Our ref.: MP09\_0187

**Subject: Exhibition of Proposed Mixed Use Building - 6-16 Atchison Street (MP09\_0187)**

Michael Woodland  
Director  
Metropolitan Projects

**Podium Atchison St EW**

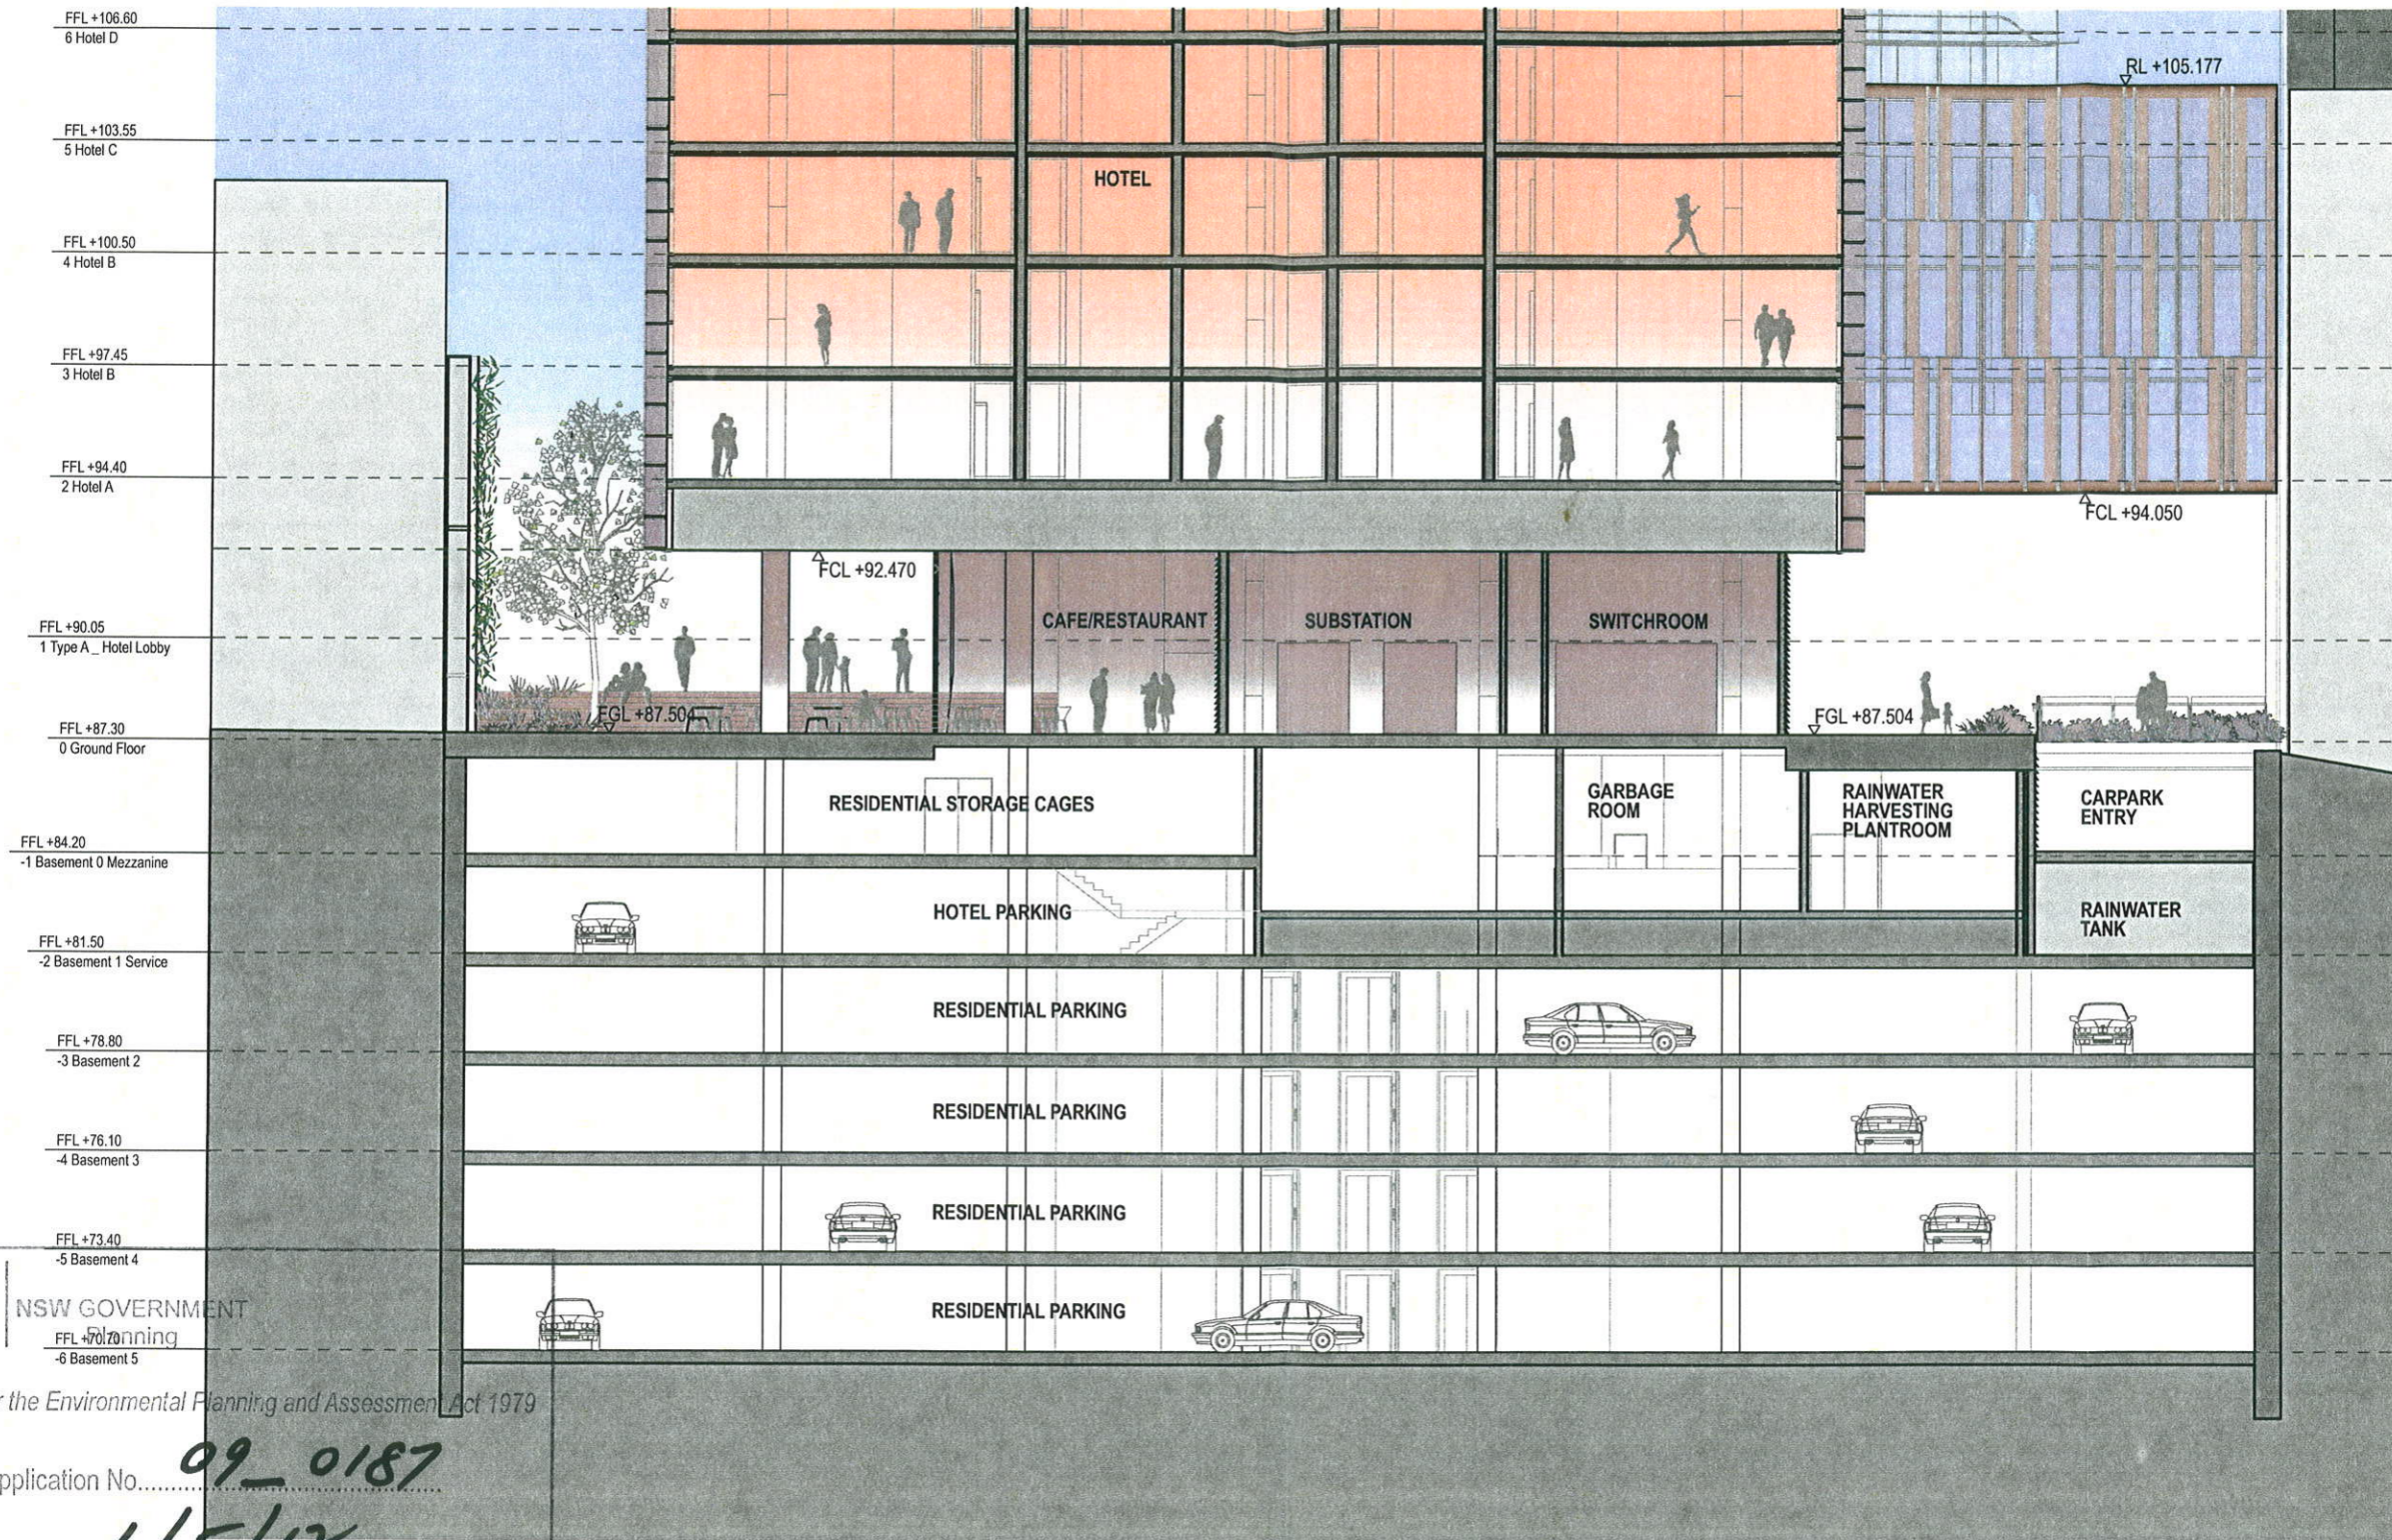
Consideration should be given to extending the podium form over the western portion of the site and to the south to Atchison Street. Podium heights should match the podium height of the adjacent "Linea" building to the west.

This analysis should include a consideration of the partial enclosure of the ground floor frontage to Atchison Street to activate the streetscape and relocation of the fire stairs and service utilities to a less prominent part of the Atchison Street frontage. Options for increasing the setback of the podium to the eastern (side) boundary should also be provided.
